Sent: 24 July 2012 11:33
To: Planning
Subject: Planning application N6/2012/1299/AD - Stadium Service Station Stanborough Road

District ref: N6/2012/1299/AD
HCC ref: WH/296/2012
HCC received: 17/07/2012
Area manager: James Dale
Case officer: Lindsey Lucas

Stadium Service Station Stanborough Road
Welwyn Garden City

Installation of illuminated and non-illuminated signage (re-branding of existing Total signage)

TITLE : TYPICAL SIGNAGE DETAILS (SHEET2)

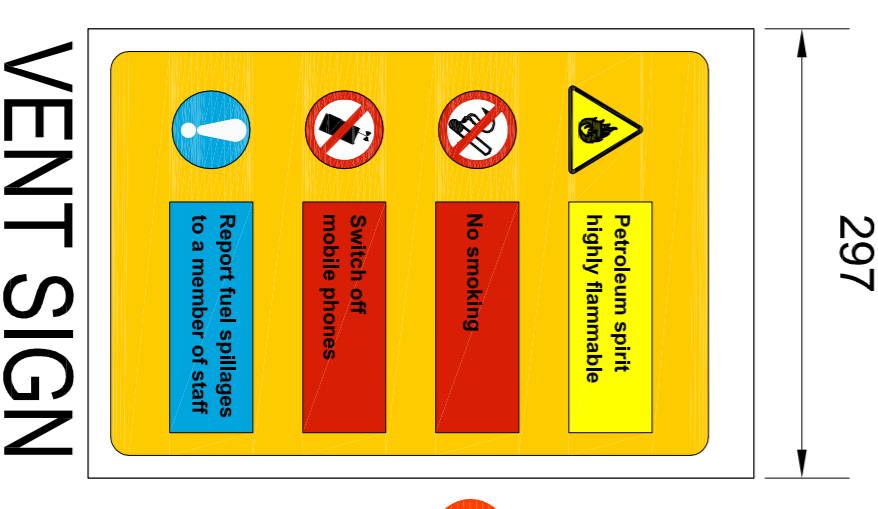
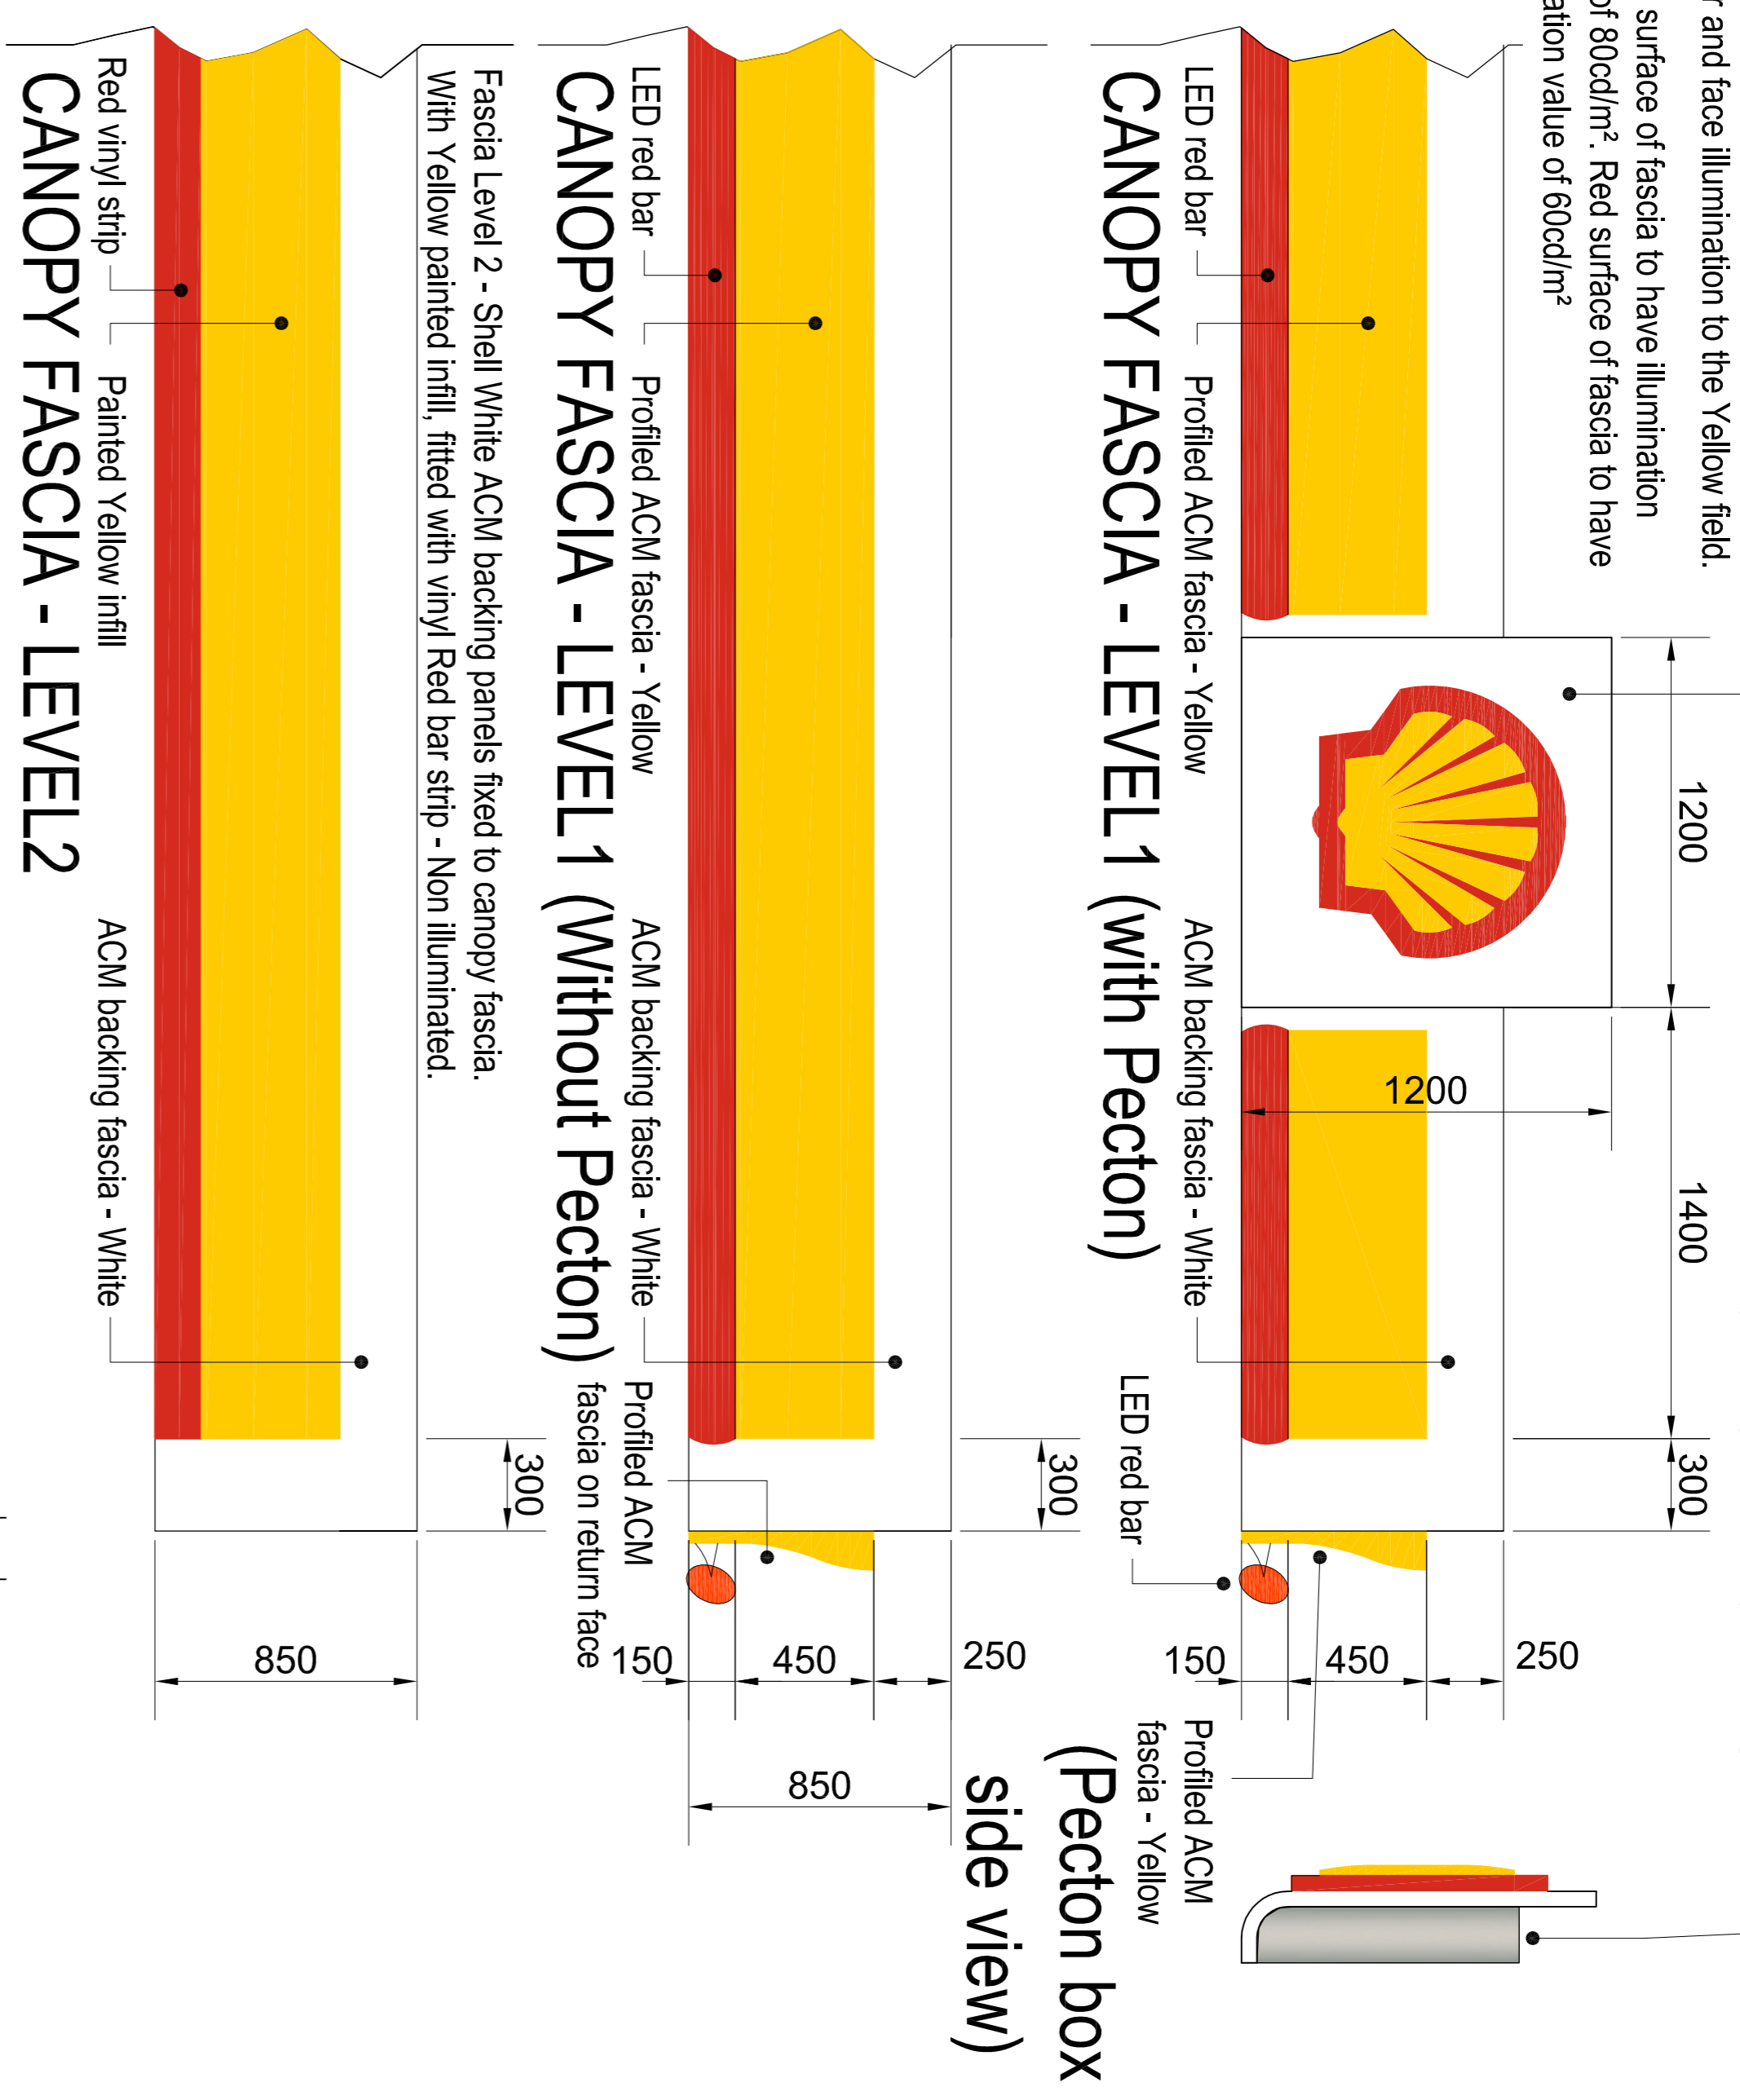
Conditions 1. The intensity of illumination shall be controlled at a level that is within the limit recommended by the Institution of Lighting Professionals in TR5 Brightness of Illuminated Advertisements(2001)

Reason: So that drivers of vehicles along the adjacent Stanborough Road are not dazzled or distracted, leading to interference to the free and safe flow of traffic along the highway.

COMMENTS: Given the proposal involves the installation of an internally illuminated signs the above recommended condition will ensure that drivers of vehicles along the adjacent public highway are not dazzled or distracted, prejudicial to highway safety Hertfordshire County Council has no other highway issues as a result of this proposal.
